Re: Status of Improvement Permit Application #17-5-41519

Andrew Currin, R.E.H.S.
Environmental Health OSWW Specialist
Harnett County Department of Public Health

SITE PLAN APPROVAL

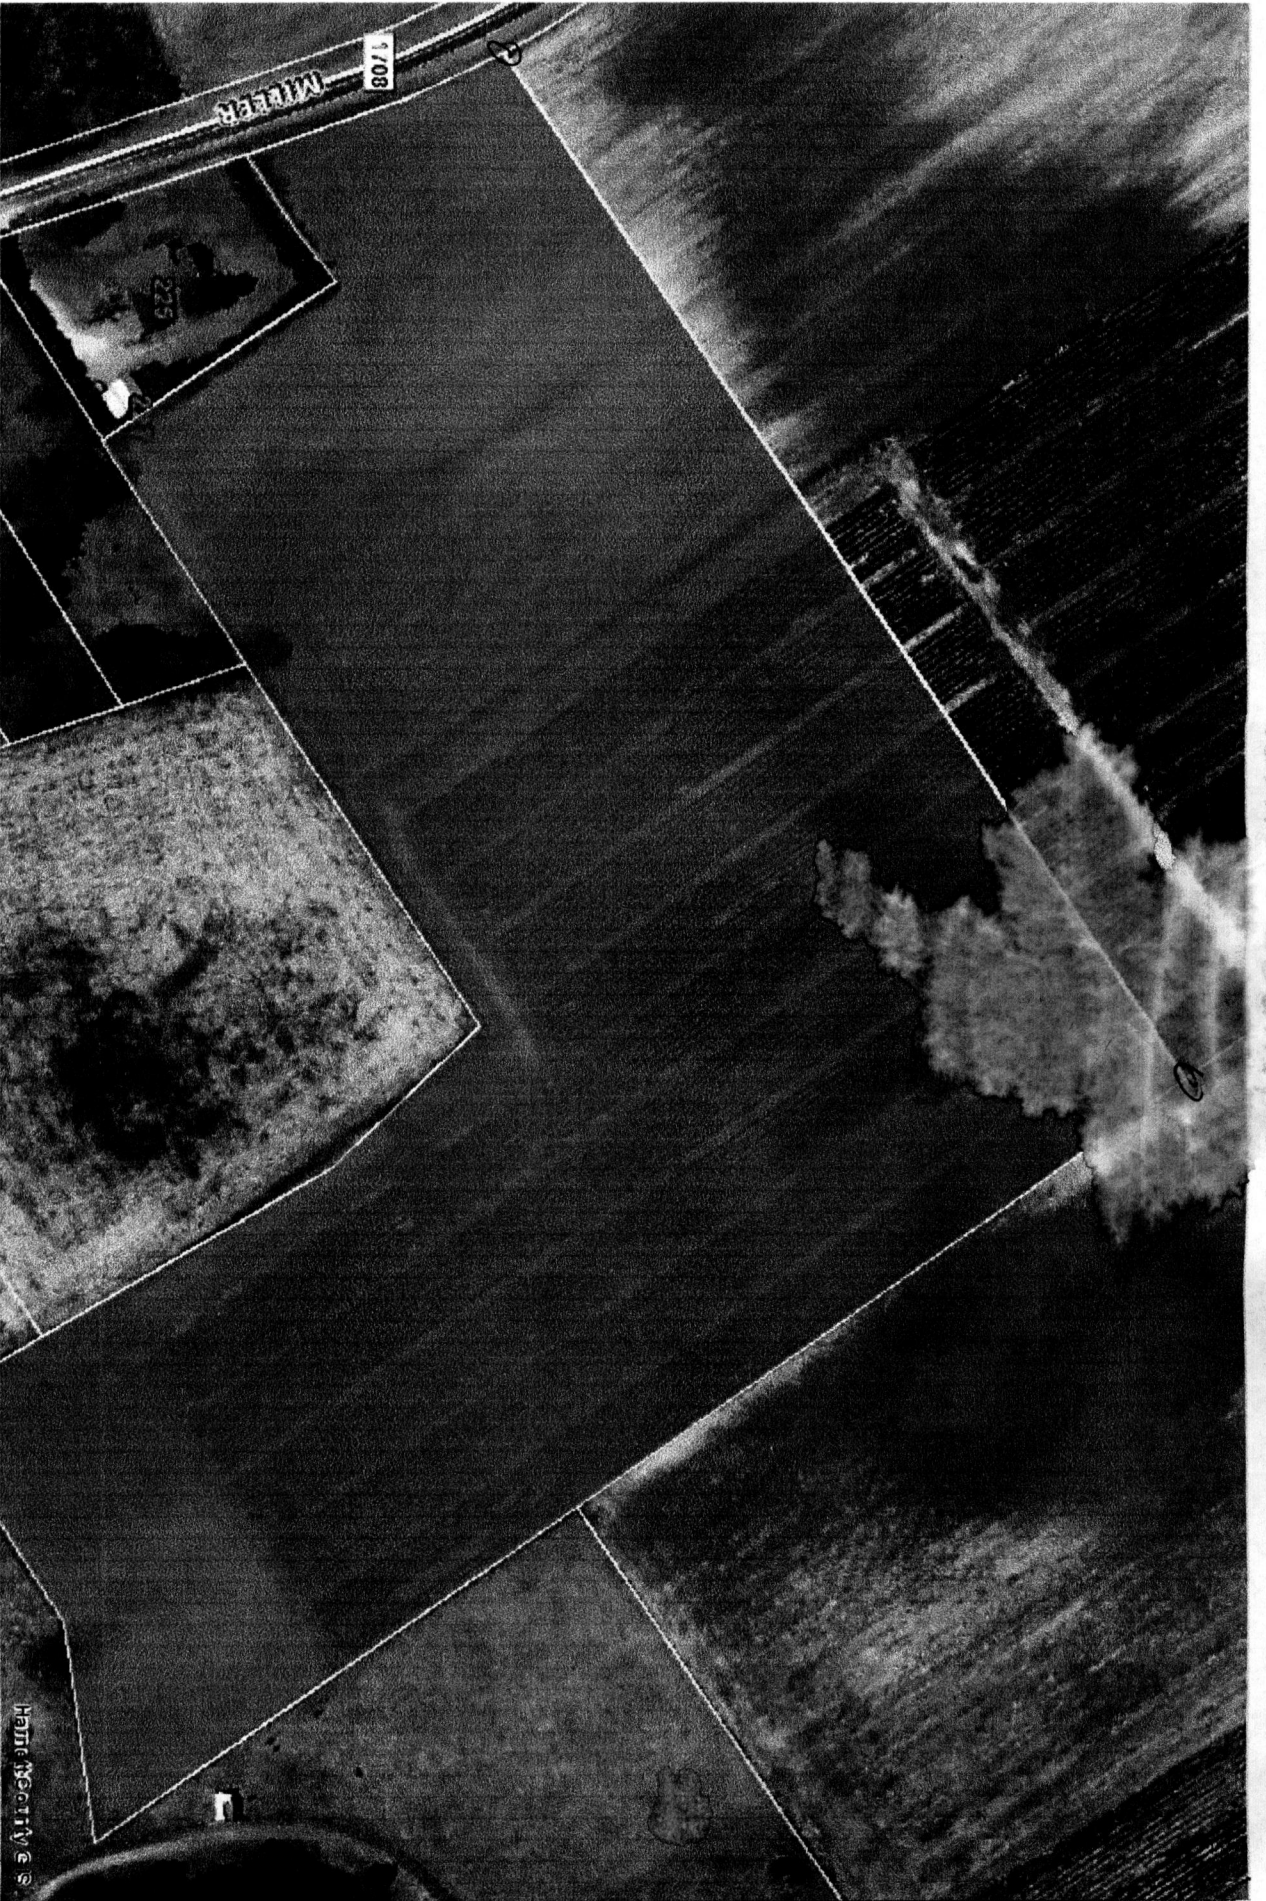
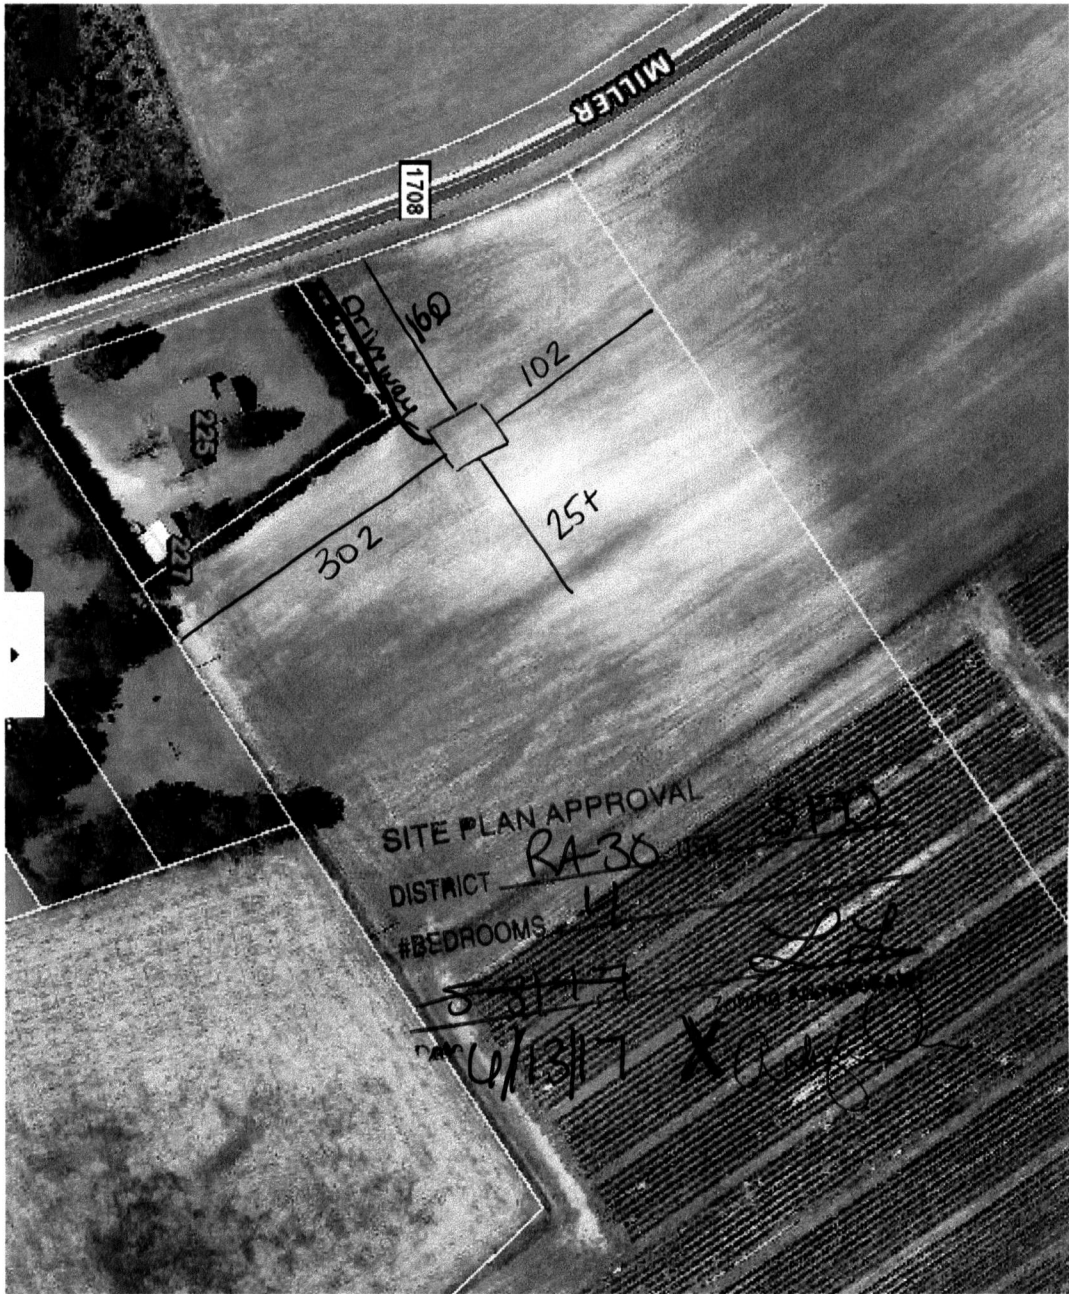
- 1. Use pink flags to mark property lines and irons that are set by surveyor need to be visible (\$25.00 fee incurred)**
- 2. Use orange flags to mark house corners (\$25.00 fee incurred)
- 3. Directions not clear to property (\$25.00 fee incurred)
- 4. Property needs only brush or vegetation removed
- 5. Driveway not shown on site plan**
- 6. Backhoe pits required
- 7. Other
